Application number: 2019/91980	
What is the application for?:	Erection of two storey side extension, front porch and formation of new vehicula
Address of the site or building:	6, Osborne Terrace, Batley, WF17 0LZ
Postcode:	WF17 5NN

BLOCK PLAN
SCALE 1:100

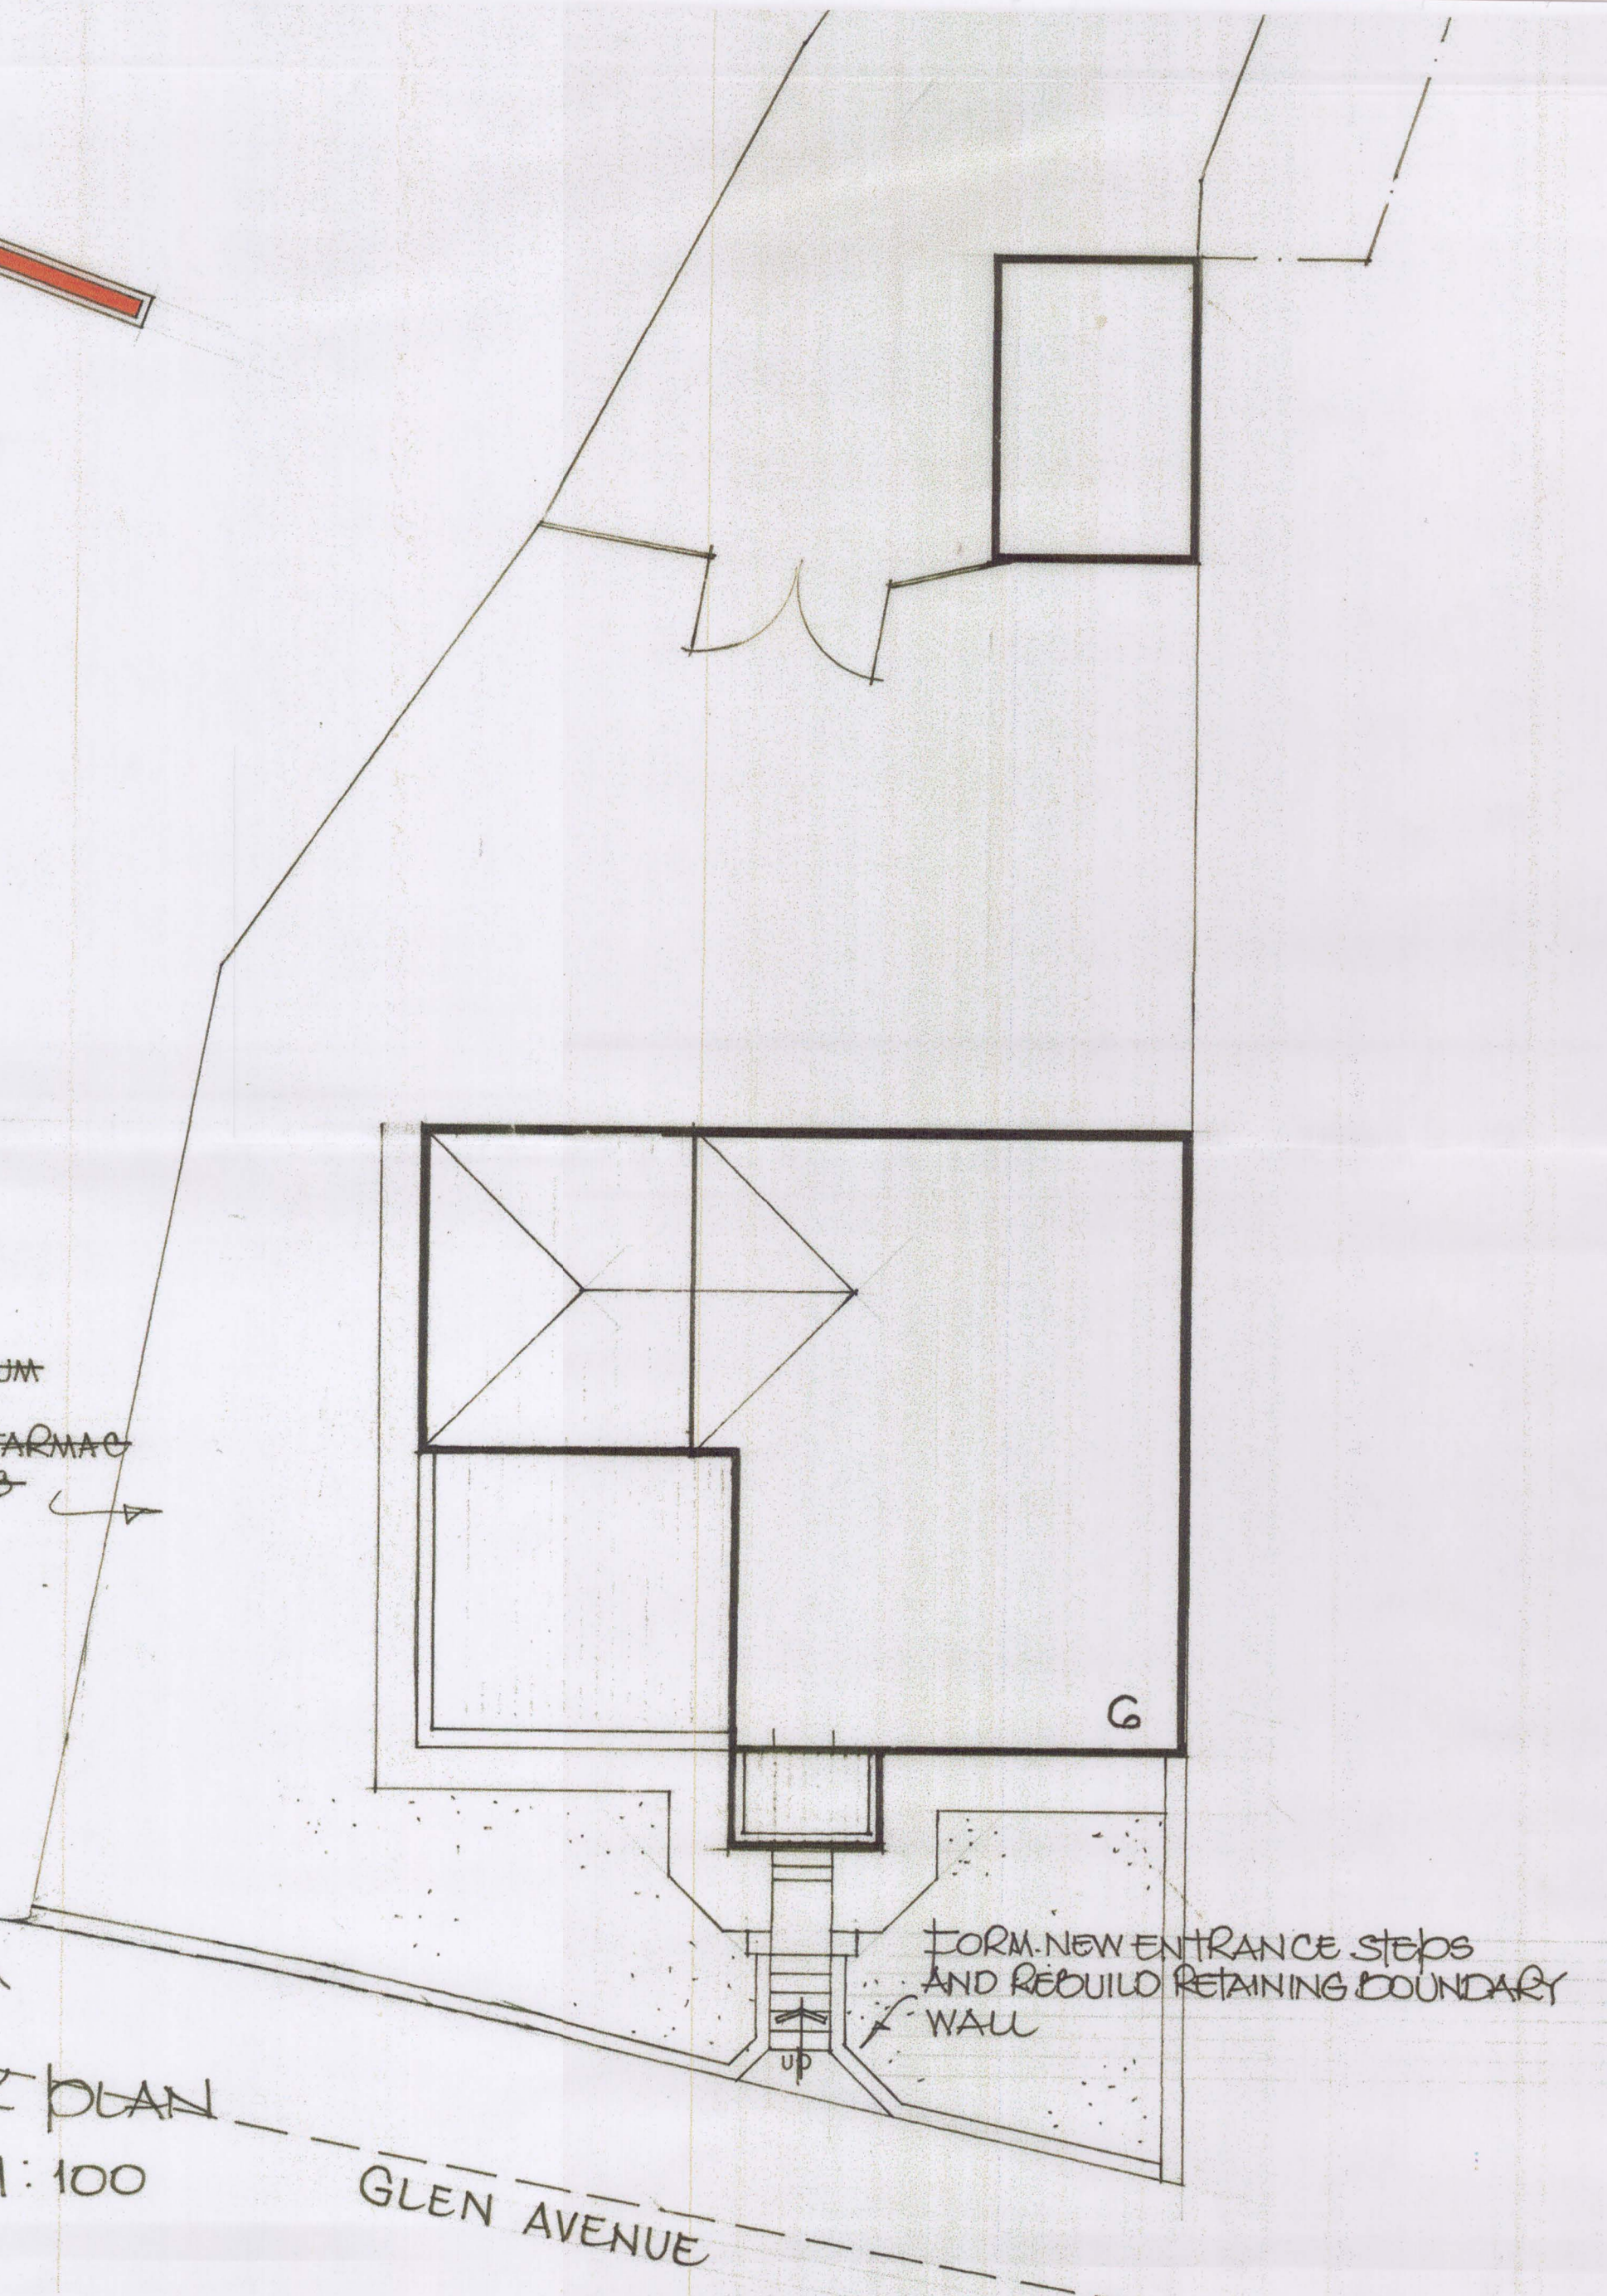
Type of comment: A general comment
This planning application appears to be identical to the previous application which was outright refused, therefore our concerns remain the same. The tree would have roots cut through to form the driveway, which would potentially make it unsafe or destroy it altogether. Secondly, the turning circle on Osborne Terrace needs to be maintained and cannot be closed off as all residents of the terrace have a right to access. Also, having read all the details and reports from the various contributors of the previously rejected application, we now appreciate the significant impact of such a large extension which may have an adverse effect so many thanks for highlighting this.
